Application No: AB/3/21/PD
Site Address: Riverside House 2 Fitzalan Road Arundel BN18 9JS
Description of works: Notification for Prior Approval under Schedule 2 Part 1 Class AA for erection of one and two additional storeys on existing dwellinghouse.

Thank you for your internet representation made on 9th February 2021 which has been recorded as an objection with the comments as follows:

Drawing Title:
PROPOSED ELEVATIONS

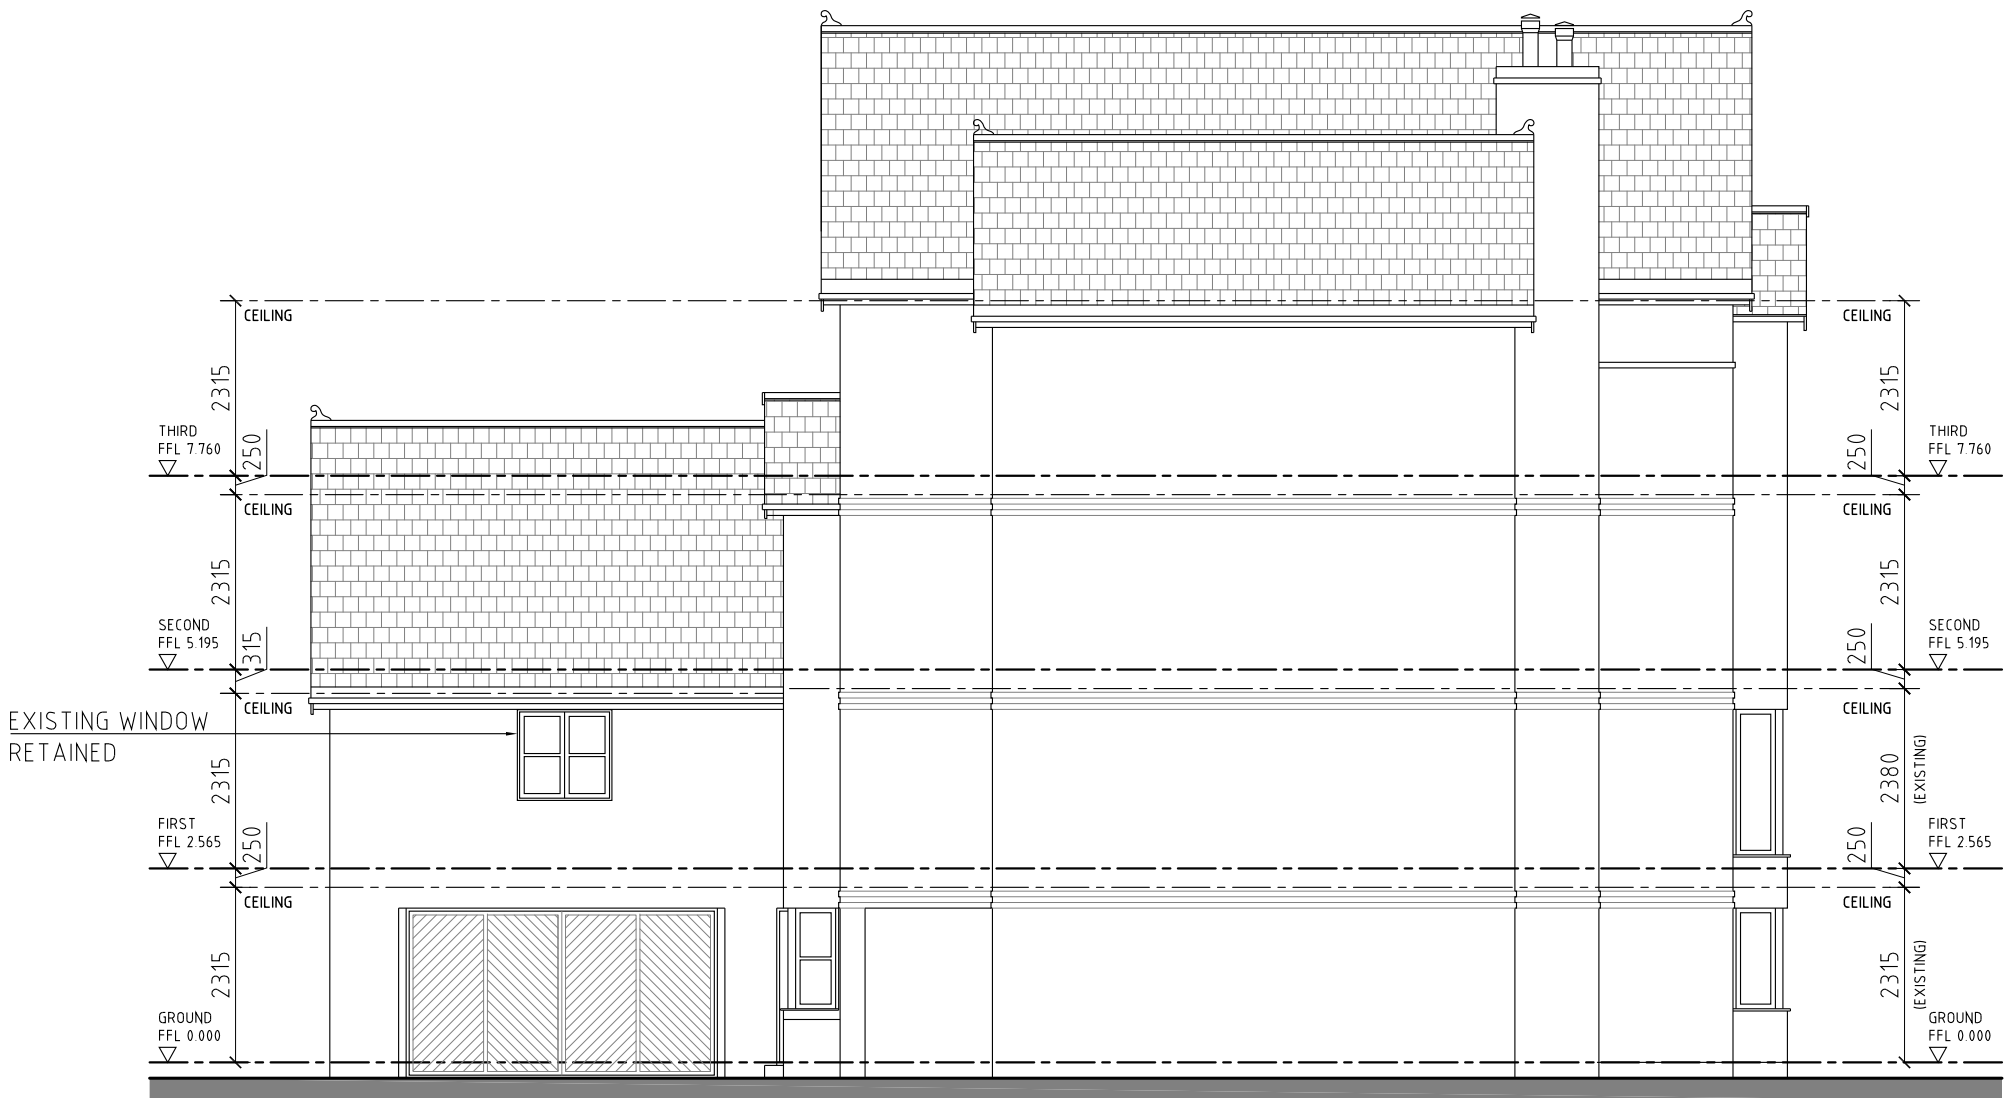
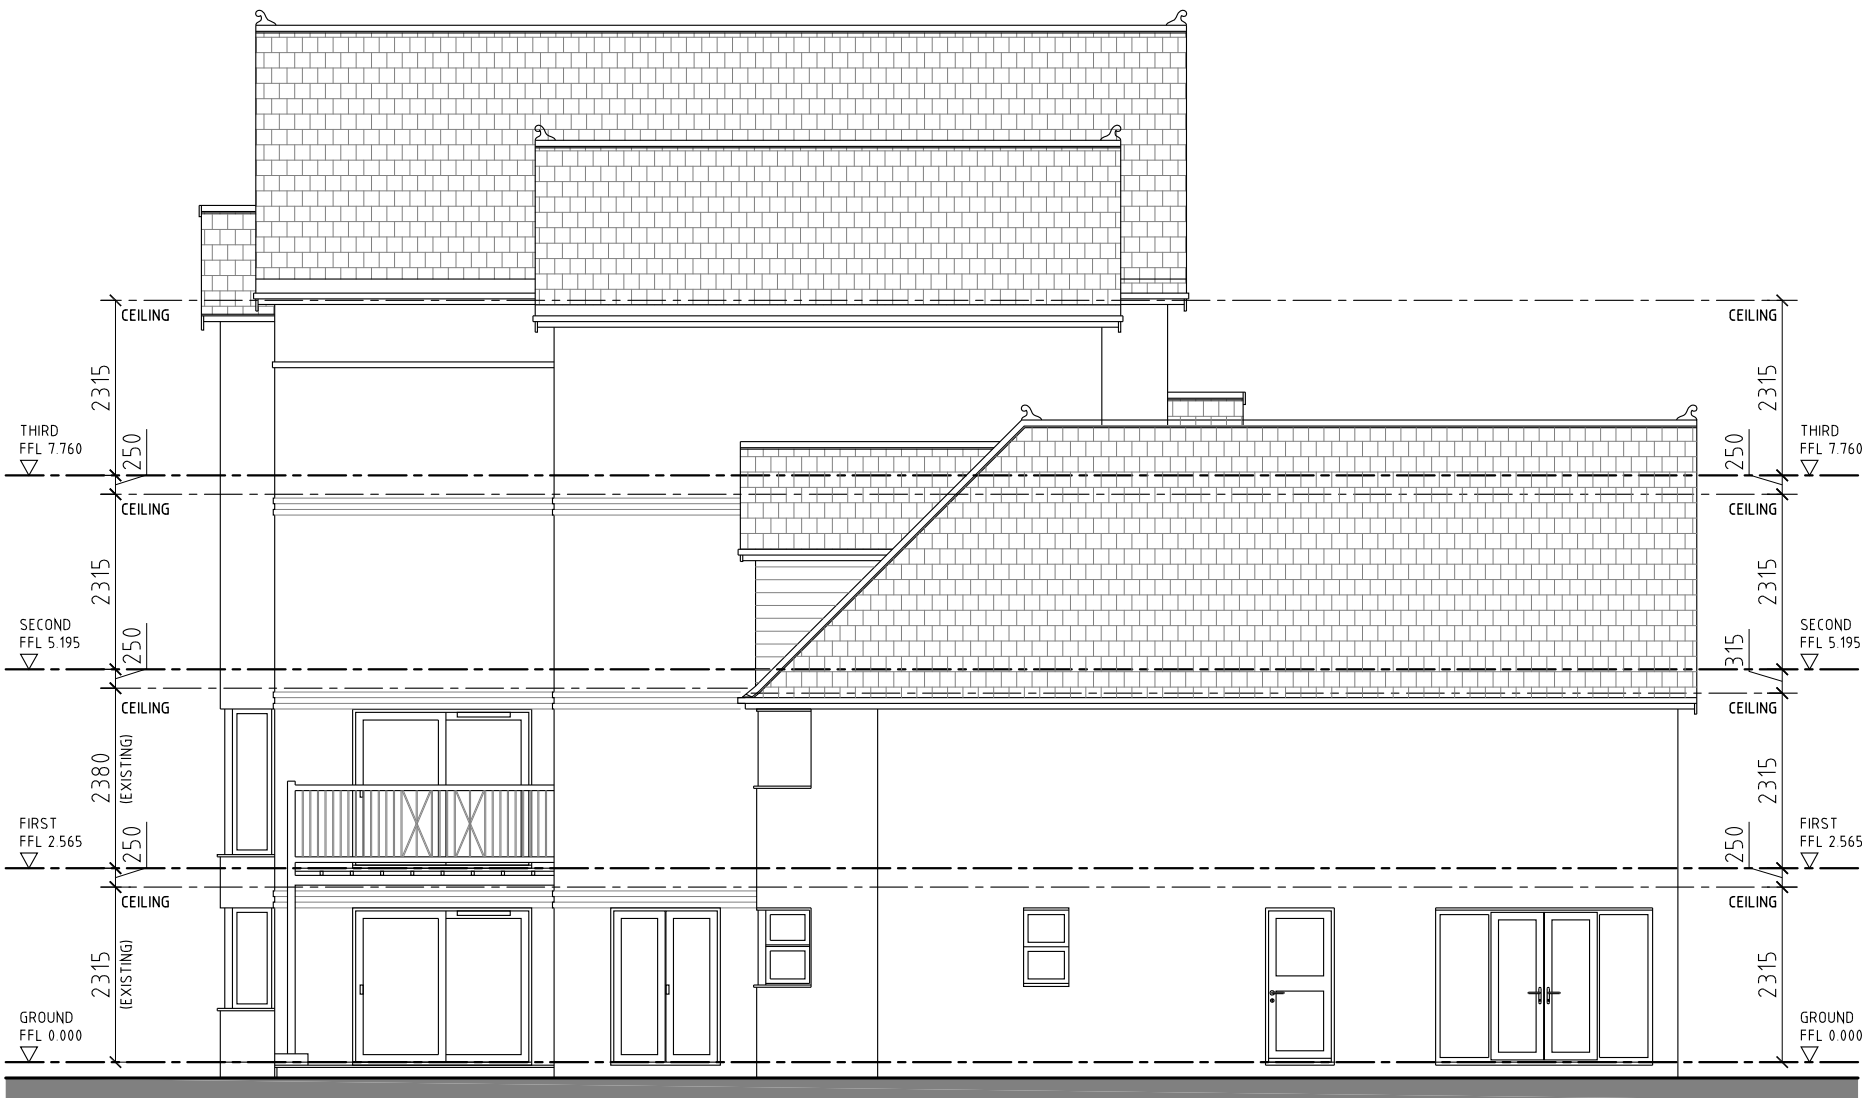
The proposed two storey extension by reason of its site coverage, bulk, height, proximity to the site boundaries and location close to the Arundel conservation area would result in a prominent and obtrusive dwelling which would adversely affect the visual amenities and the character of the area and would not preserve or enhance the setting of the Conservation Area. It would therefore be contrary to the policies laid out in the Arun District Local Plan and the National Planning Policy Framework.
